Application Ref:	2025/0533			 Ribble Valley Borough Council www.ribblevalley.gov.uk
Date Inspected:	26/08/2025	Site Notice:	26/08/2025	
Officer:	EP			
DELEGATED ITEM FILE REPORT:				APPROVAL

Development Description:	Proposed erection of a single storey rear extension following demolition of existing conservatory.
Site Address/Location:	7 Horton Lodge Horton Skipton BD23 3JX

PROPOSED SITE PLAN

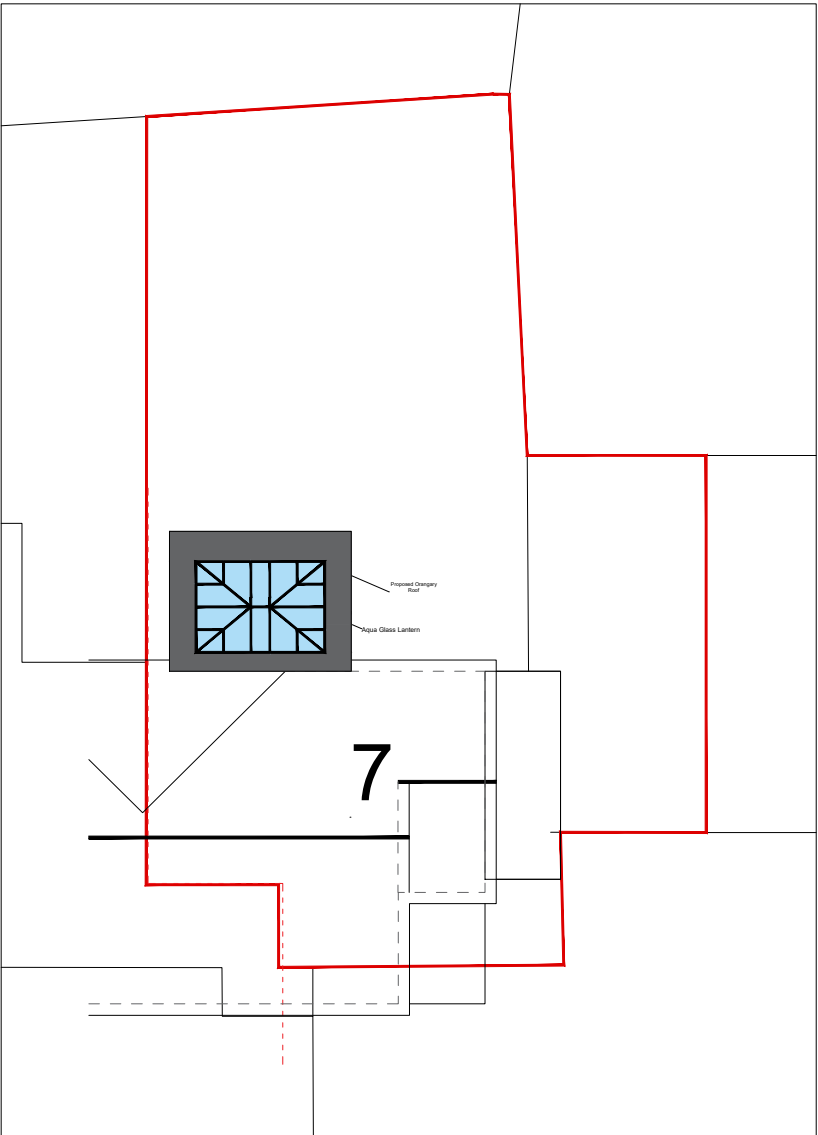
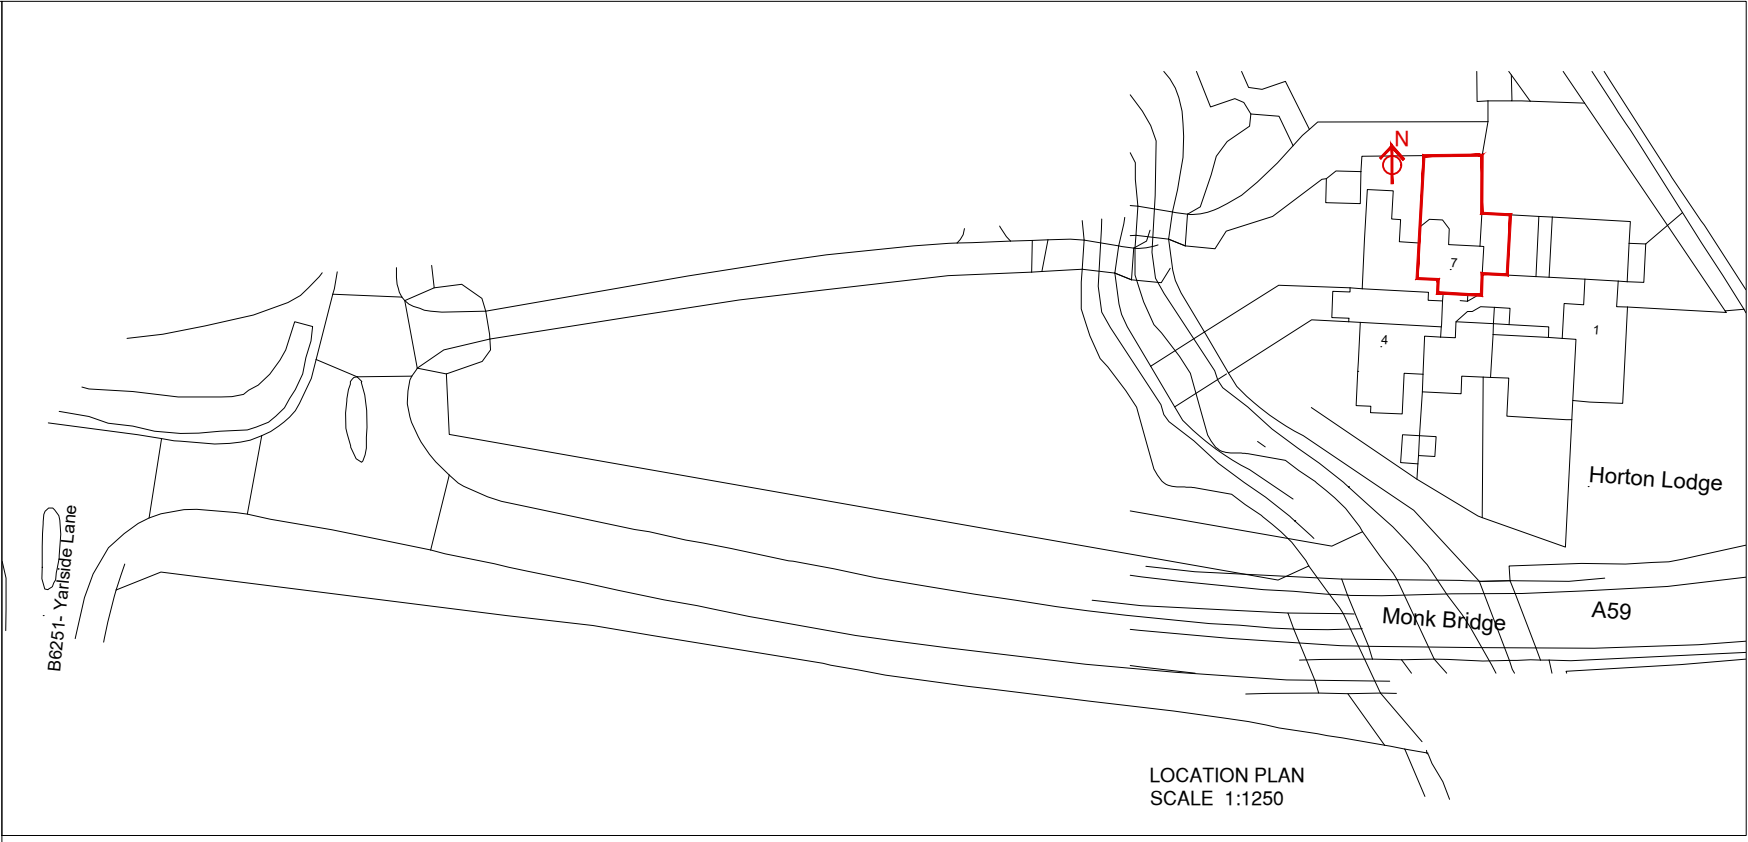
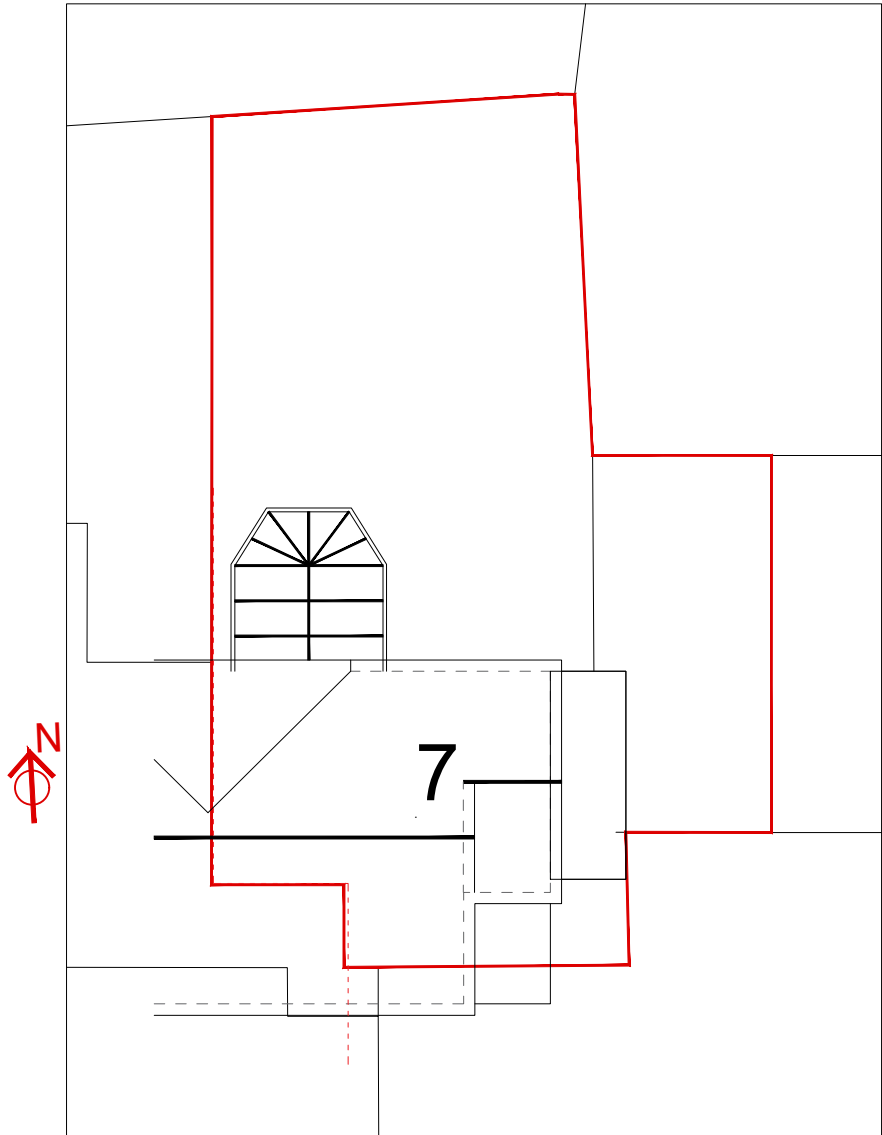
The application dwelling has one adjoining neighbour to the west known as No.5 Horton Lodge. The proposed extension is to be located at the western side of the dwelling adjacent to the shared boundary with No.5.

PROPOSED GROUND FLOOR PLAN

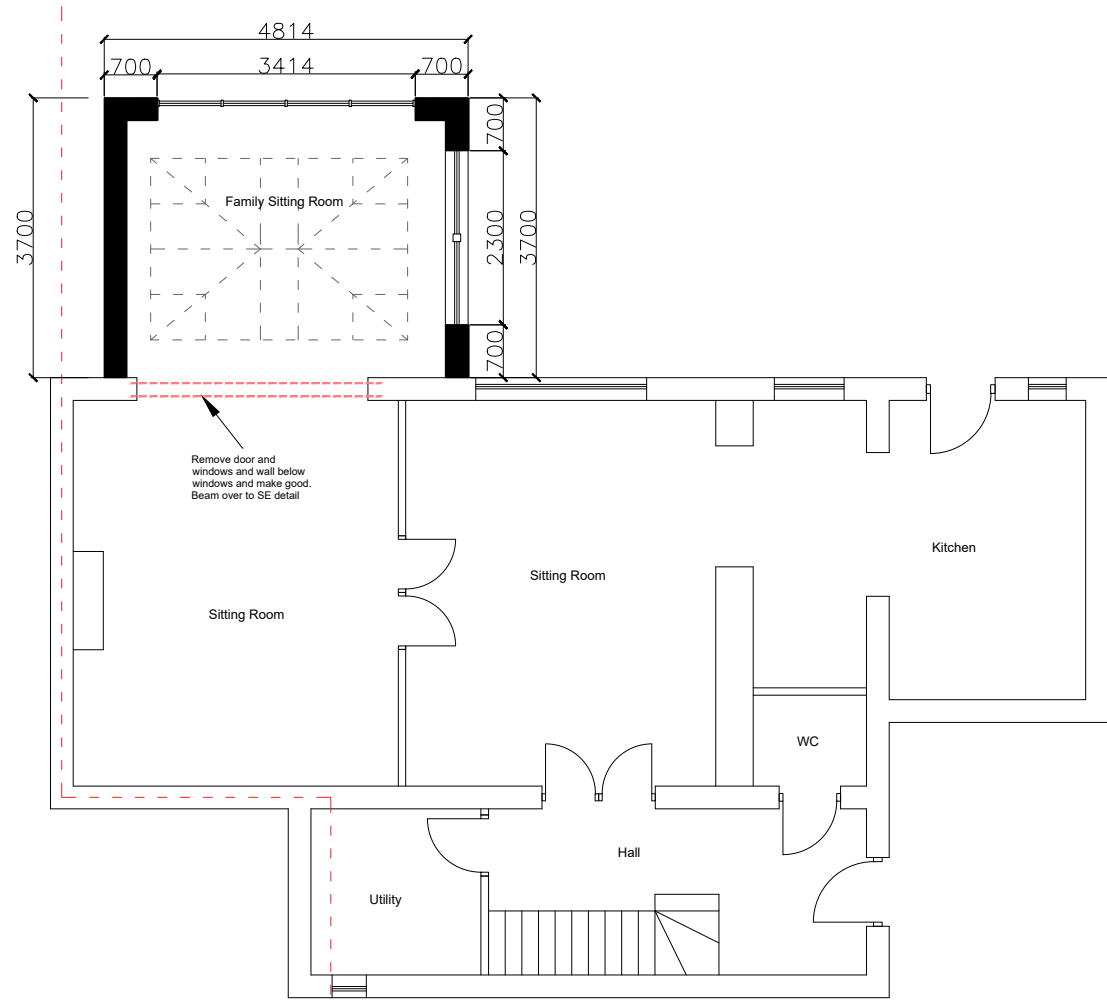
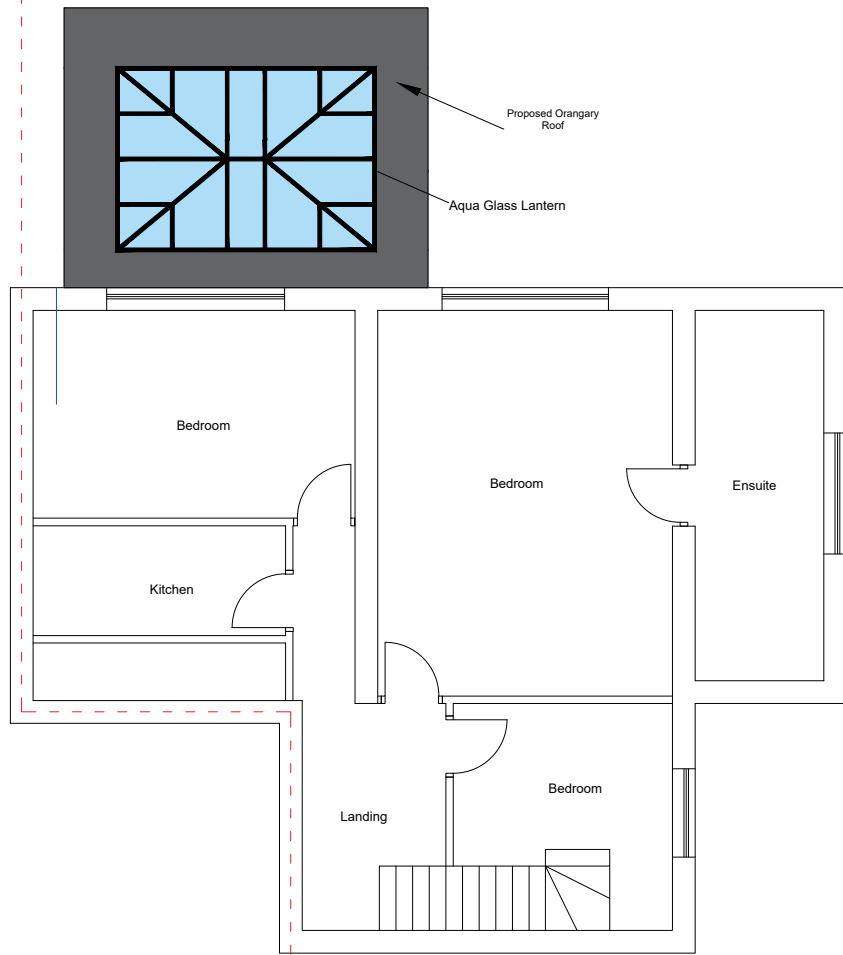
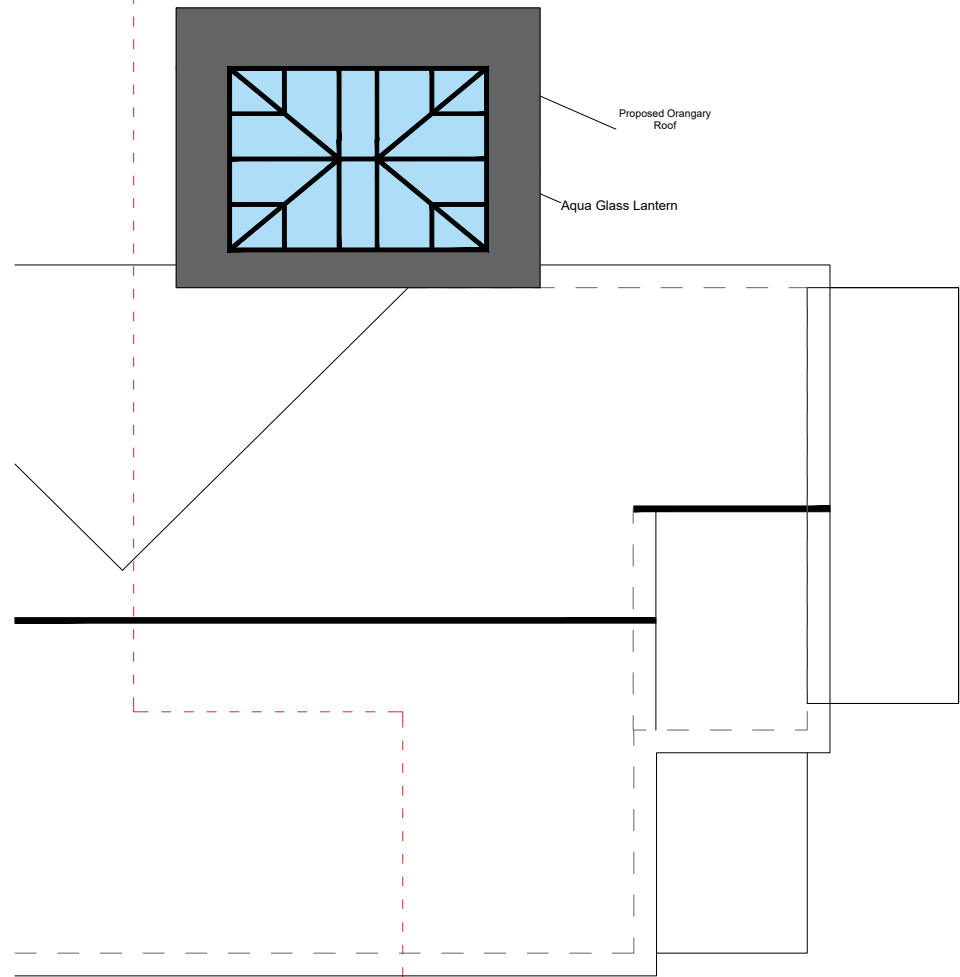
There is an existing conservatory at the application site which is approximately 0.5m from the shared boundary. The proposed rear extension will be located in a similar position albeit it greater in width. The proposed extension will be flat roof in design, with an eave's height of 2.85m. This is marginally greater than the eaves height of the conservatory, which measures approximately 2.4m in height to the eaves, but the difference will be offset by the flat roof nature of the development compared to the pitched roof of the existing conservatory. In terms of length. The existing conservatory has a maximum length of approximately 4m but features a chamfer at approximately 2.8m.

Overall, the scale of the extension is slightly larger than the existing conservatory. As such, there may be a slight increase light lost or overbearing impact to the habitable windows on the rear elevation of the neighbouring property resultant. However, this would be marginal when compared with the current arrangement, particularly taking into account existing boundary treatment and northerly facing rear elevations, and would not be substantial enough to warrant refusal. Furthermore, the existing conservatory has a completely glazed western side elevation. As such, from a privacy perspective, the proposed extension provides a betterment.

The proposed development is located to the rear of the site and as such does not host a readily visible position from within the public realm. The proposed extension is modest in footprint when read in conjunction with the host dwelling and surrounding development. The extension will measure 4.8m by 3.7m in width and length remaining entirely subservient to the host dwelling.

In regard to materials, the extension will be constructed in sandstone to the elevations with stone mullions and sills. The doors and windows will be white upvc to match the existing dwelling. As such, the proposal will integrate sufficiently into the site.
